**KIRKLEES METROPOLITAN COUNCIL
INVESTMENT & REGENERATION SERVICE**

DELEGATED DECISION TO DETERMINE PLANNING APPLICATIONS

Reference No:	2023/62/93715/W
Site Address:	Waverley United Reformed Church, Waverley Road, Huddersfield, HD1 5NA
Description:	Alterations to and change of use of teaching institute (use class F1) to form 10 apartments (use class C3) with associated external works including formation of car parking (within a Conservation Area)
Recommending Officer:	William Simcock

Officer Report – 2023/93715

**Proposed Second Floor**  
1 : 100

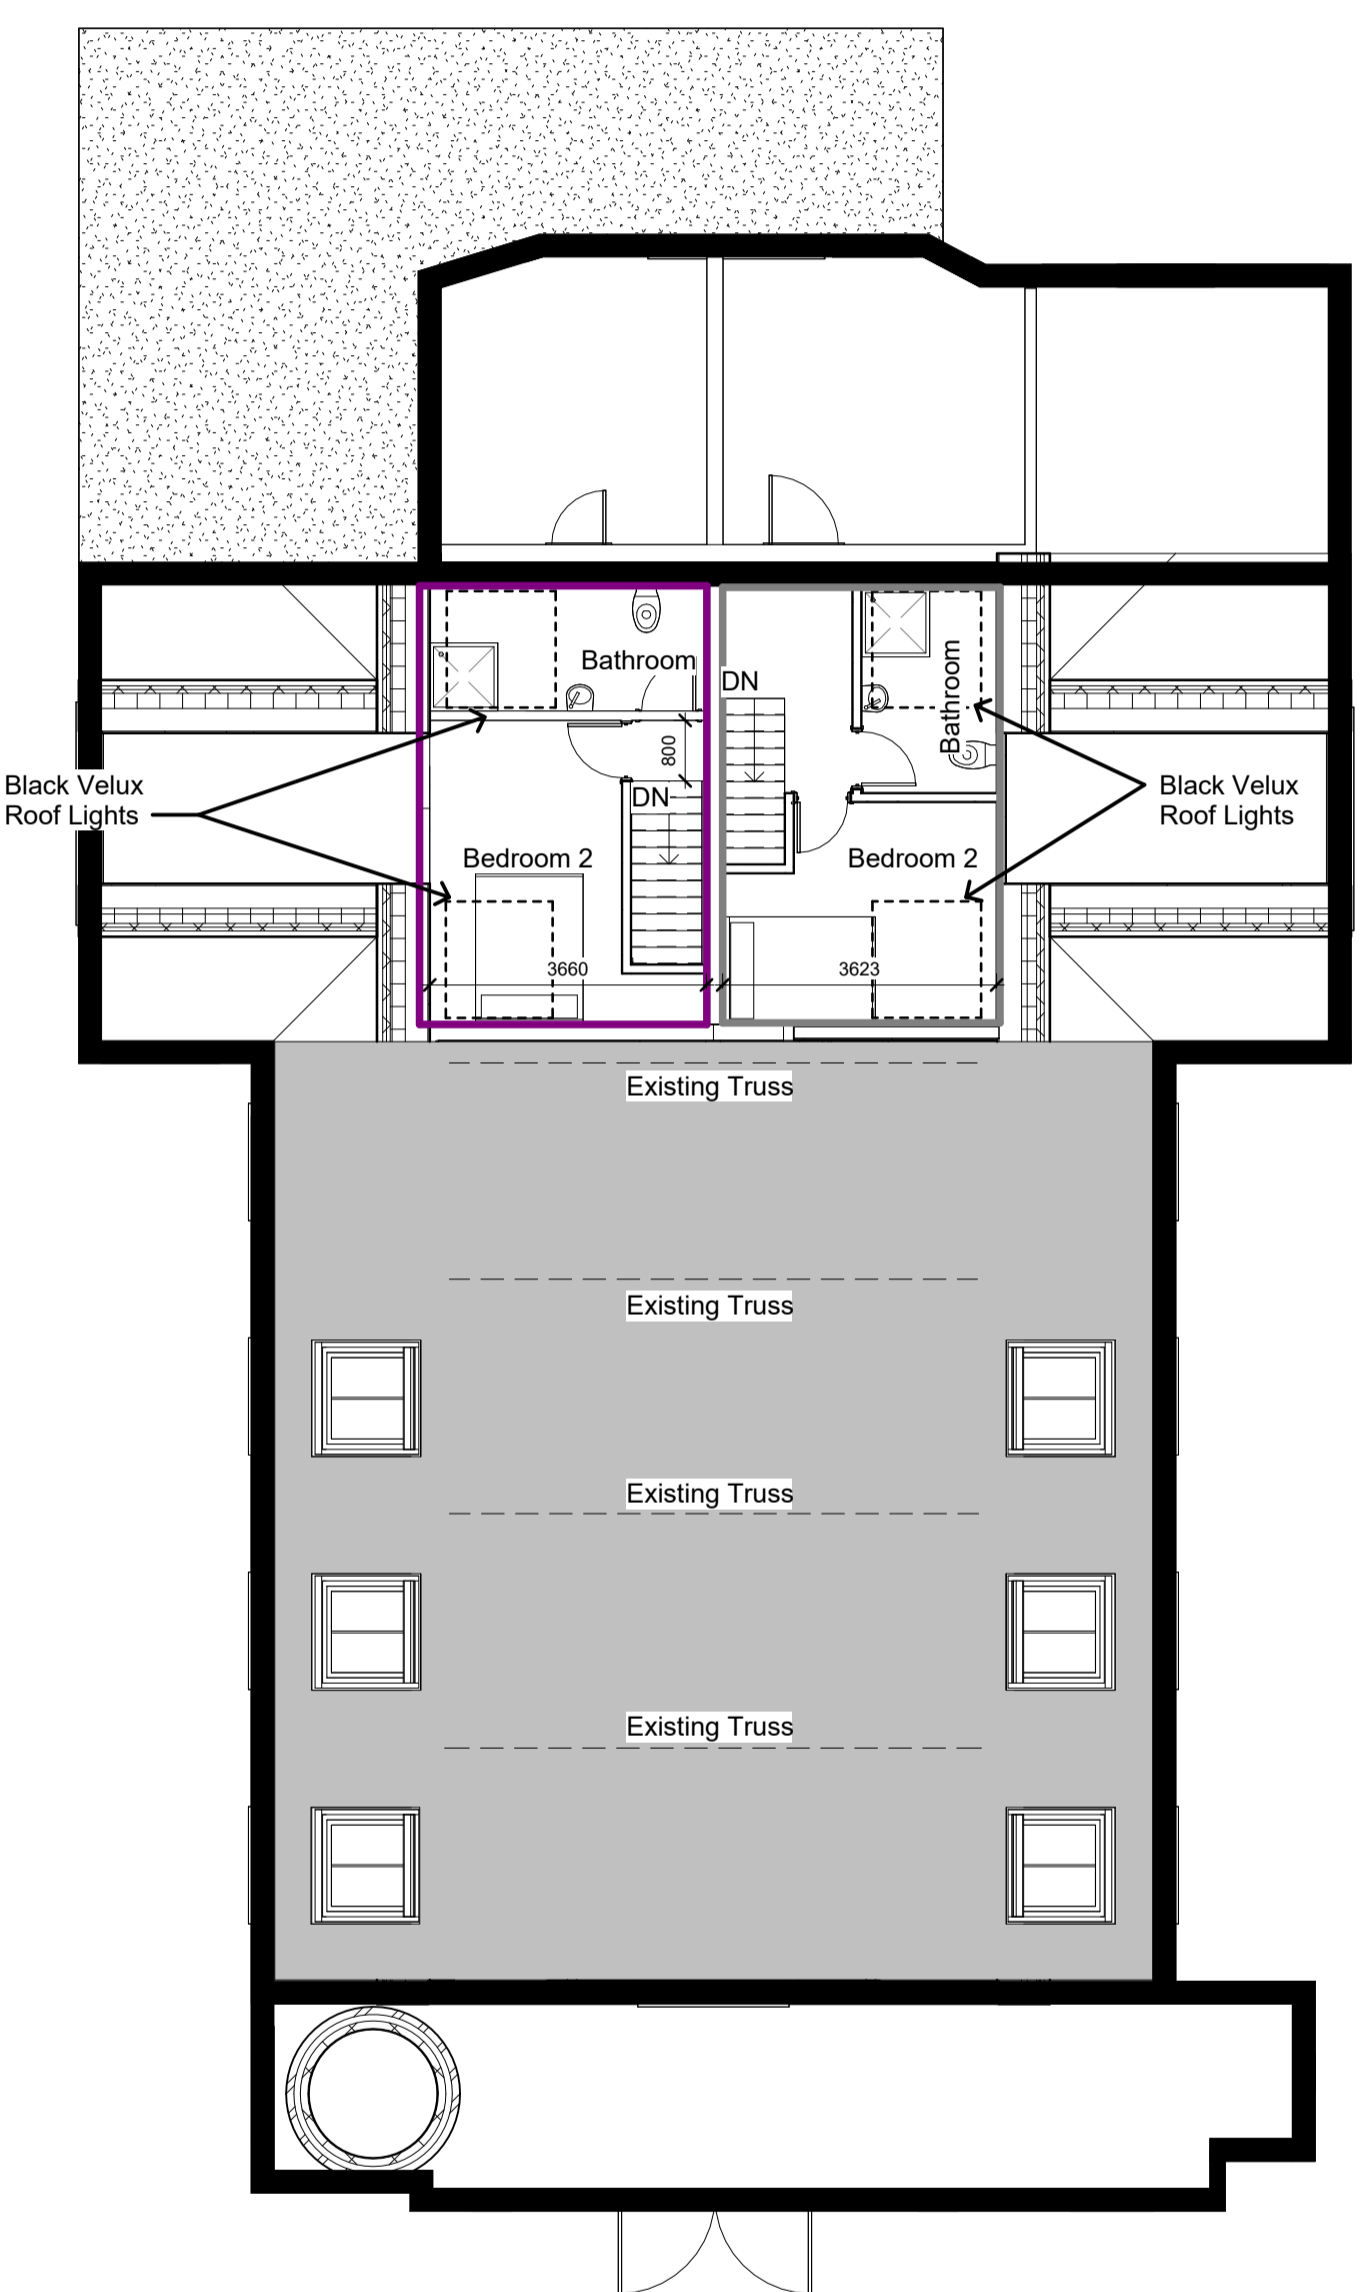
It is unclear from the submitted documents how fire protection and noise transmission would be addressed at first floor level without harming the character of the tall windows (both the smaller side windows with tracery and the larger side gable windows). A condition should be applied requiring

As originally submitted, one dwelling would have been of sub-standard floorspace. In the plans now under consideration, following the reduction in the number of units and rearrangement of internal floorspace, all apartments would meet or exceed the NDSS standards. The smallest single-bedroom apartment, Flat 4, would provide 40sqm of floorspace, which is 3sqm in excess of the recommended minimum. The 2-bed maisonettes would provide 80sqm, as against the minimum standard which is 70sqm.

Flats 1 and 2 would have their windows (bedroom, and combined living accommodation for studio flat 2) only just over 2m from the eastern site boundary. Such a situation would normally be deemed unsatisfactory from the point of view of outlook and privacy, but it is noted that the floor levels in the building, which are higher than natural ground levels on the western side, would ensure that the windows would be well above the level of the boundary fence and would therefore not have their light or outlook obstructed. Moreover, the building on the adjacent site is not in residential use and it is considered that its users would not suffer from being overlooked. Whilst the privacy of future occupiers might be somewhat compromised as a result, future residents would be aware of this and it is on balance judged acceptable.

The bedroom windows in Flats 5 and 6 would have a car parked adjacent to them. Similar arrangements are normally discouraged as they affect the outlook for future residents. In this instance it is considered that there is no realistic alternative, given the limited space within the curtilage of the building, and can be accepted.

In response, amended and additional plans including a window schedule with photographs and brief descriptions were submitted. The window schedule is cross-referenced to the revised proposed elevation TR-A23-0802-006 rev G and floor plans TR-A23-0802-005 rev G.
